Ribble Valley Borough Council
Housing & Development Control

Application no: **3/2022/0791**

Address: **Twitter Bridge Farm Twitter Bridge Farm Twitter Lane Waddington BB7 3LG**

Proposal: **Substitution of house type for the conversion of the barn. Previously approved under 3/2018/0750.**

Site: Twitter Bridge Barn Twitter Lane Waddington Clitheroe BB7 3LG	
Client:	
Date: 21.07.22	Scale: 1:100 @ A1
Project No: TBB/C: Dwg 03	Drawn: BS
Amendments:

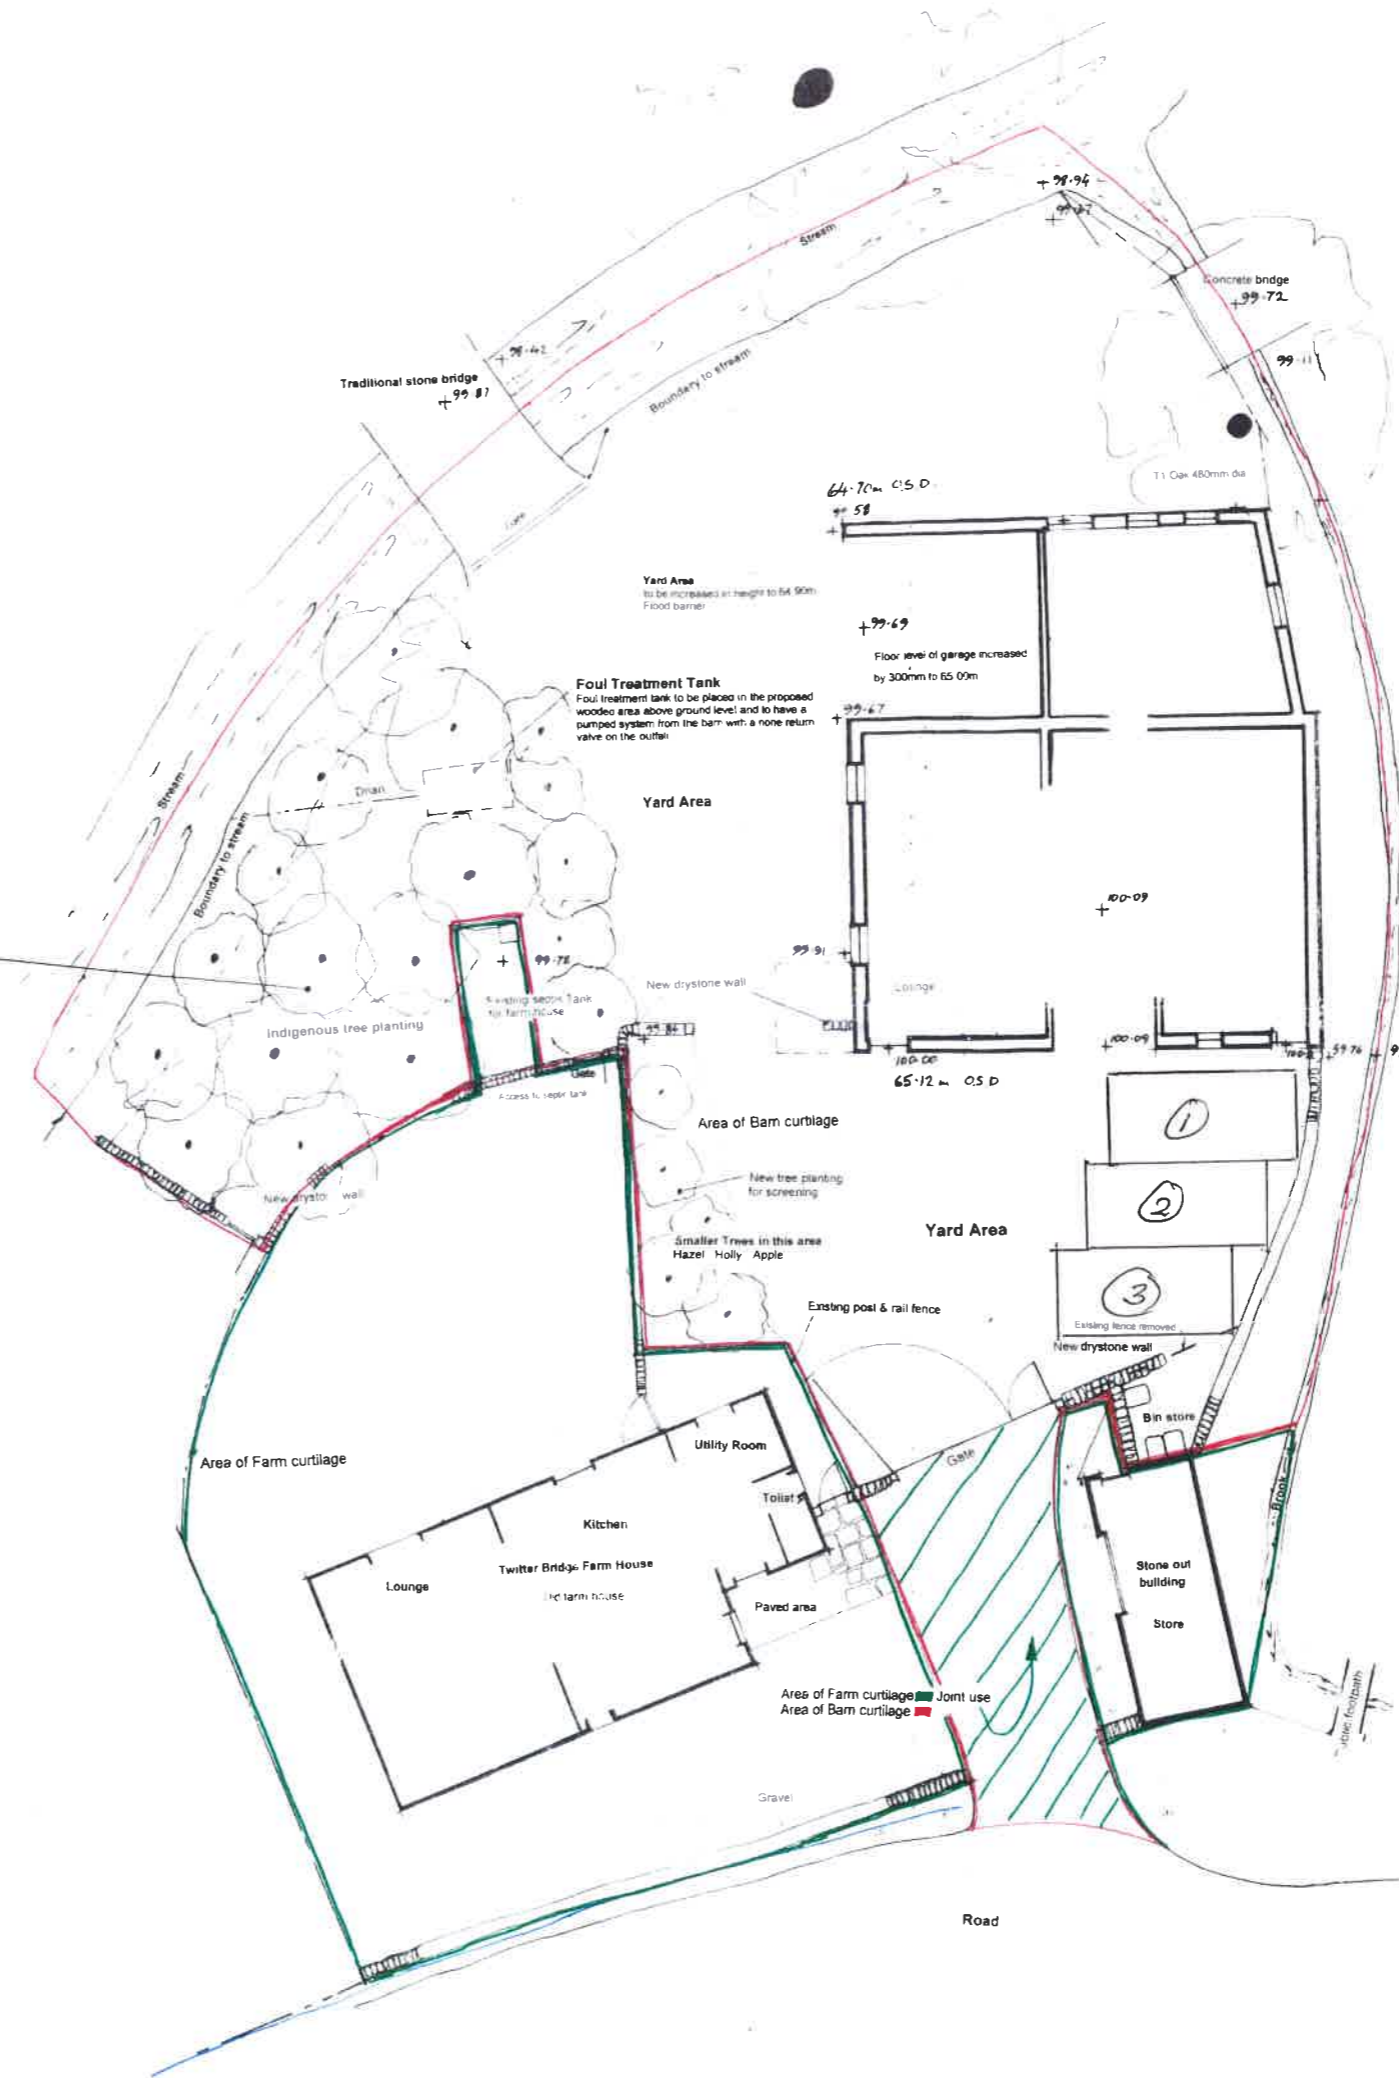
As a result, as shown on Avalon drawing number TBB/01 Dwg 03 the parking arrangements at the site has changed meaning that the 3 provided car parking spaces will be located on the yard. This complies with the LHAs guidance and so the LHA have no objection to the proposal.

1. The development hereby permitted shall not be occupied until such time as the parking and turning facilities have been implemented in accordance with Avalon drawing number TBB/01 Dwg 03. Thereafter the onsite parking provision shall be so maintained in perpetuity.
